Proposal: Submission of Details Pursuant to Conditions: 2 (Material Samples), 8 (Tree Protection/Removal), 11 (Cycle Parking), 15 (External Lighting and CCTV Cameras), 18 (Noise Protection Scheme) and 19 (Acoustic Report) on Planning Permission 6/2016/1739/MAJ dated 02/02/2017

CCTV SYSTEM

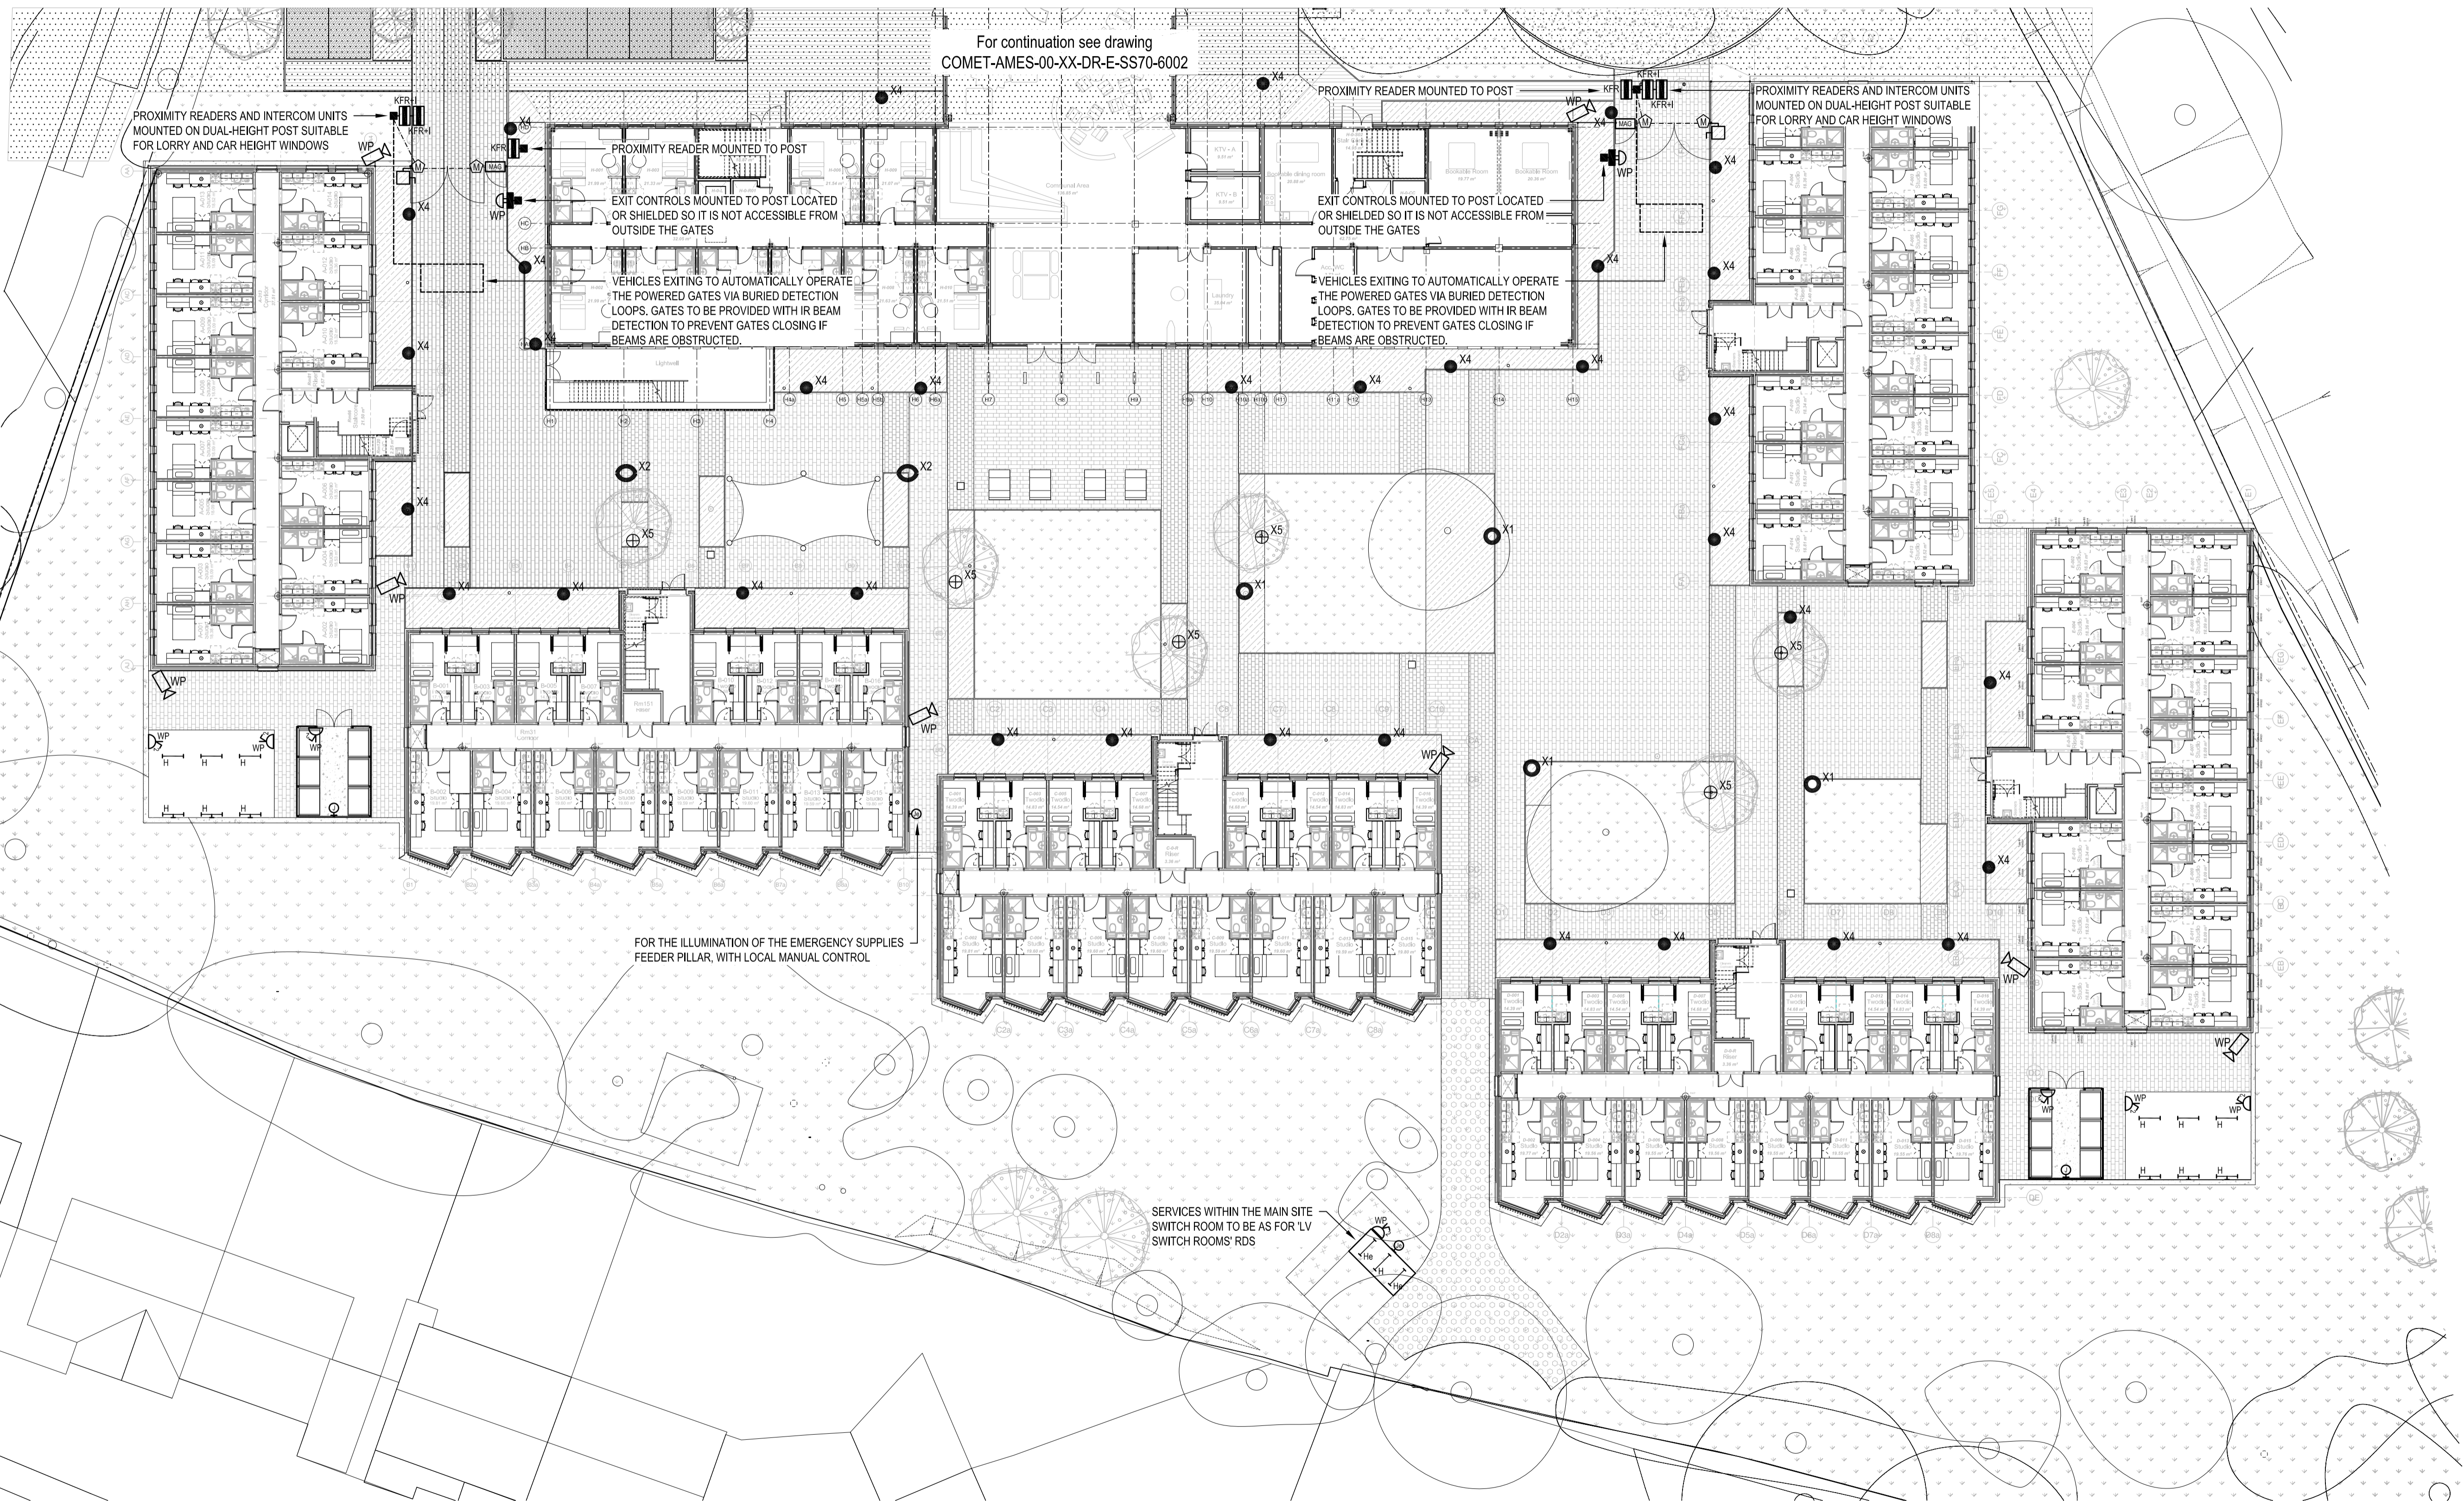
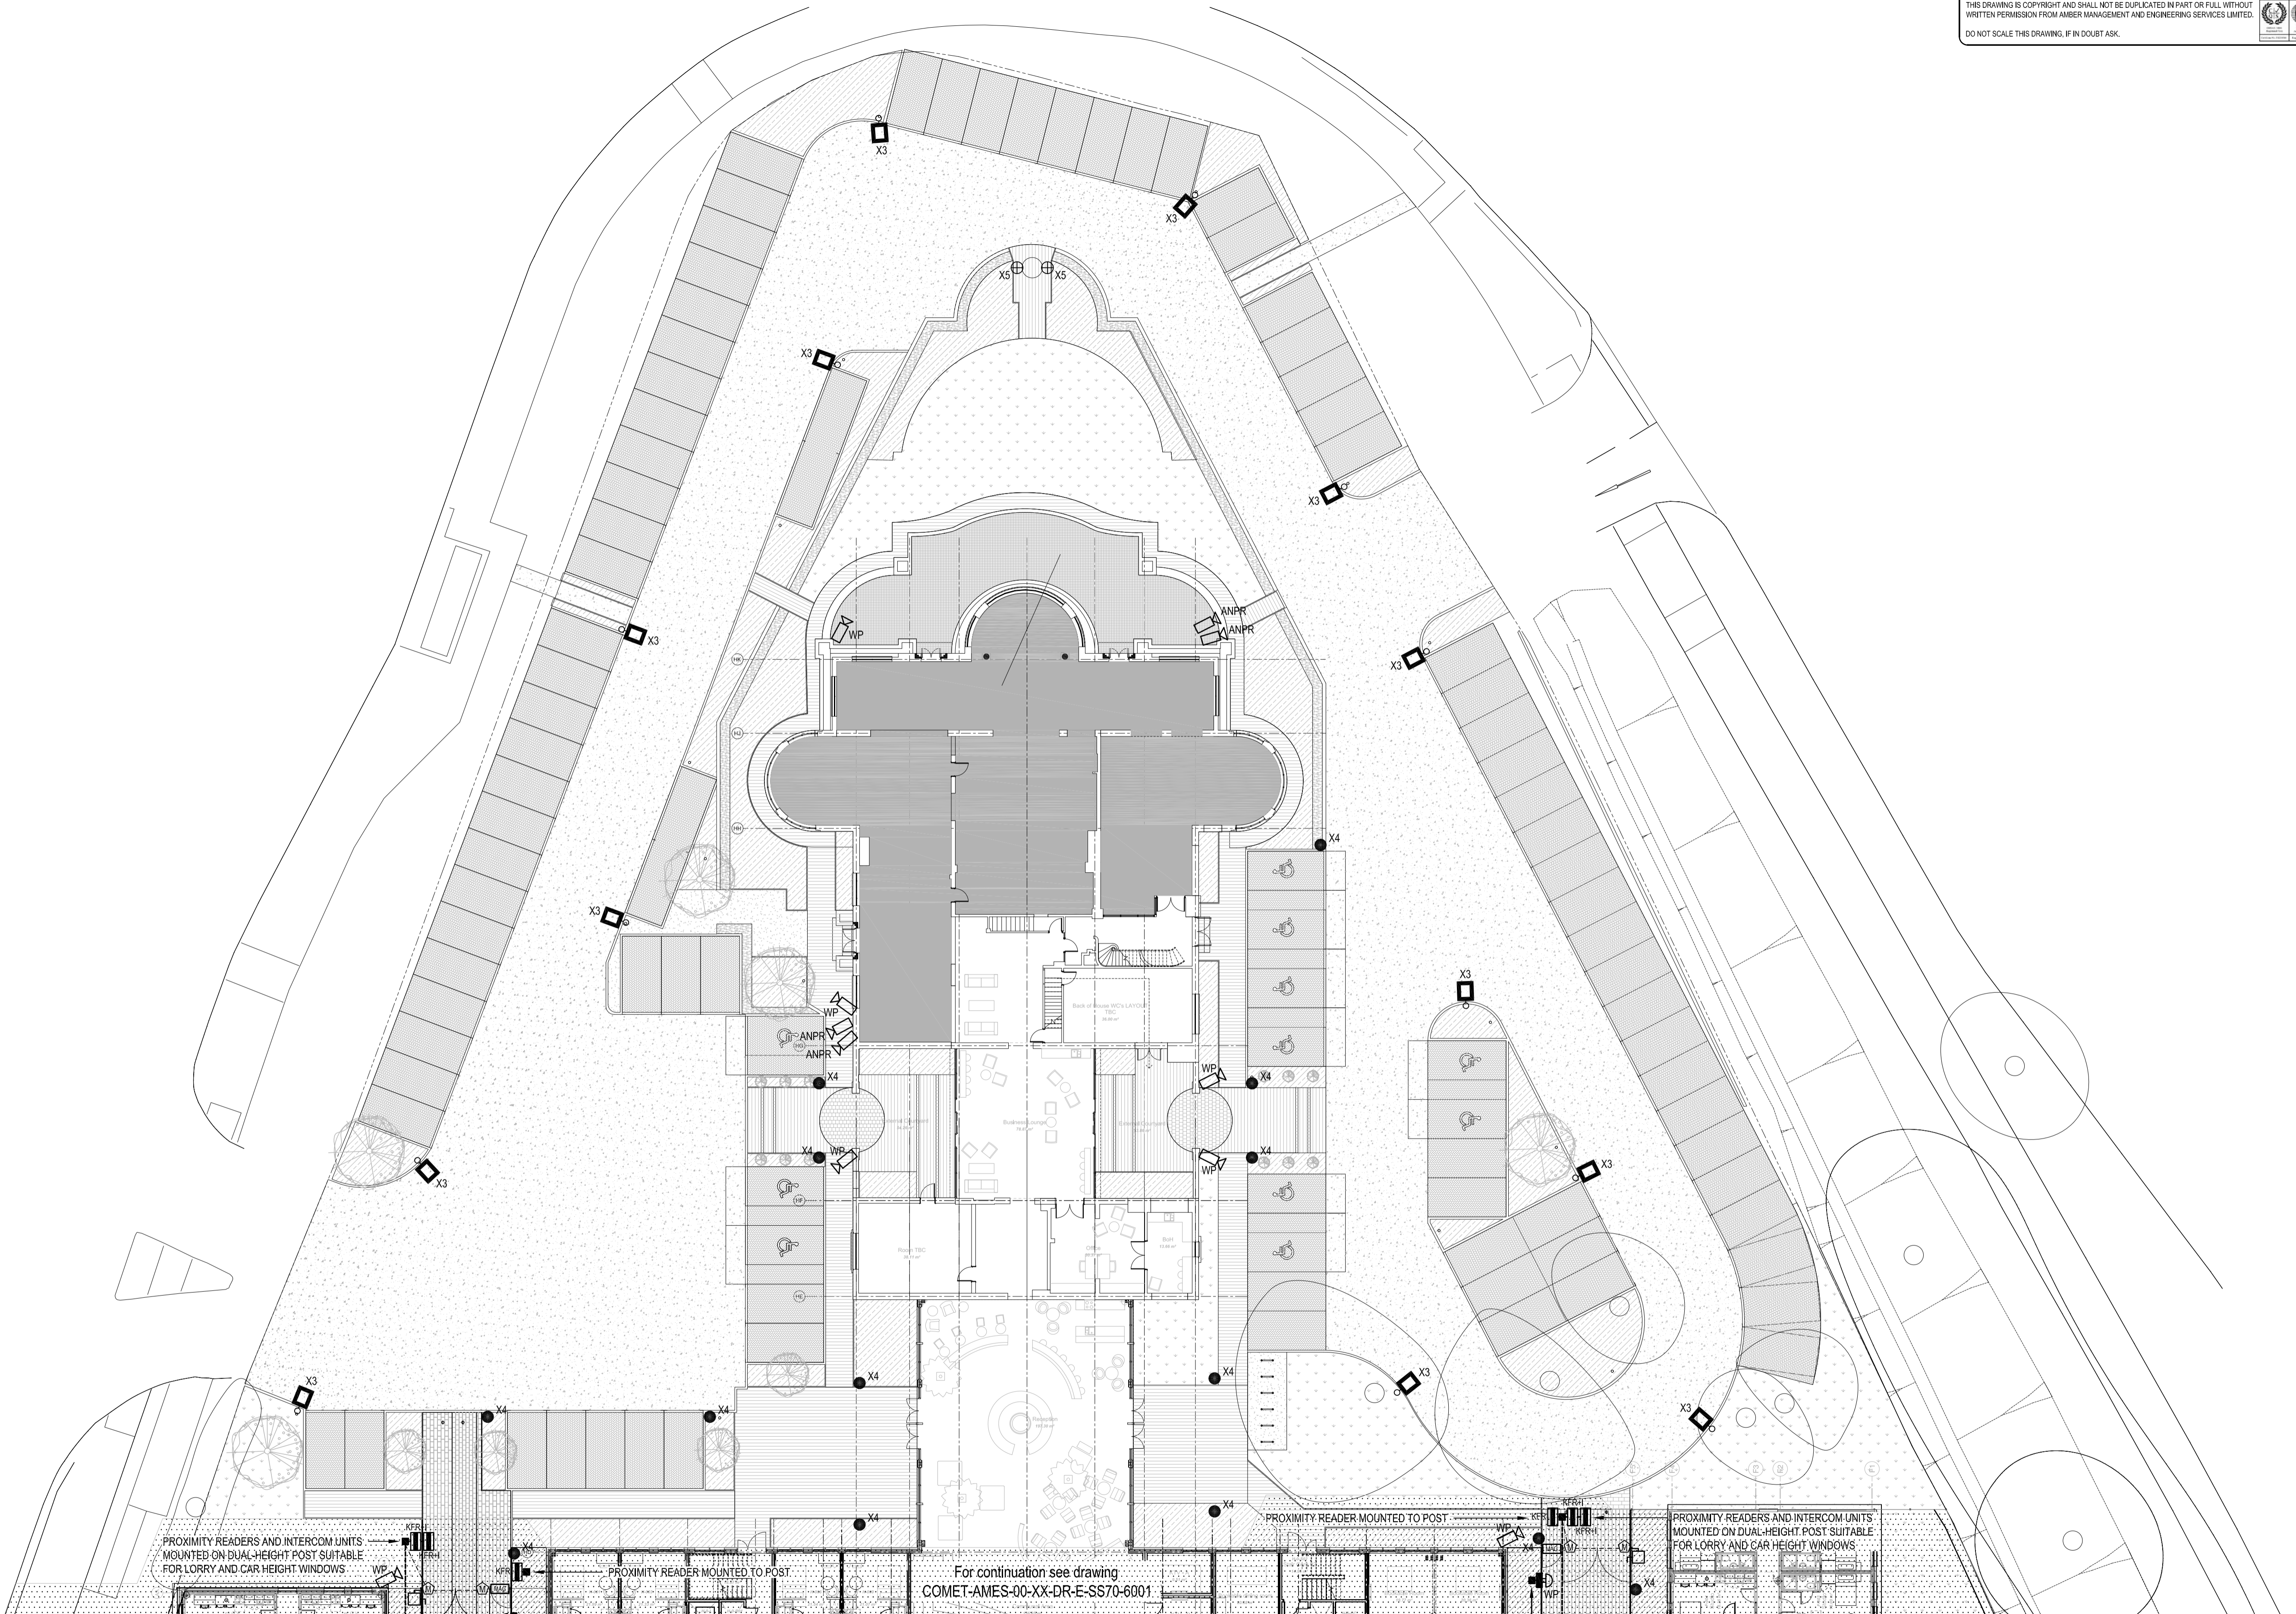
No vertical lux diagrams have been provided to enable an assessment of potential light ingress into windows, therefore, Condition 15 cannot be discharged.
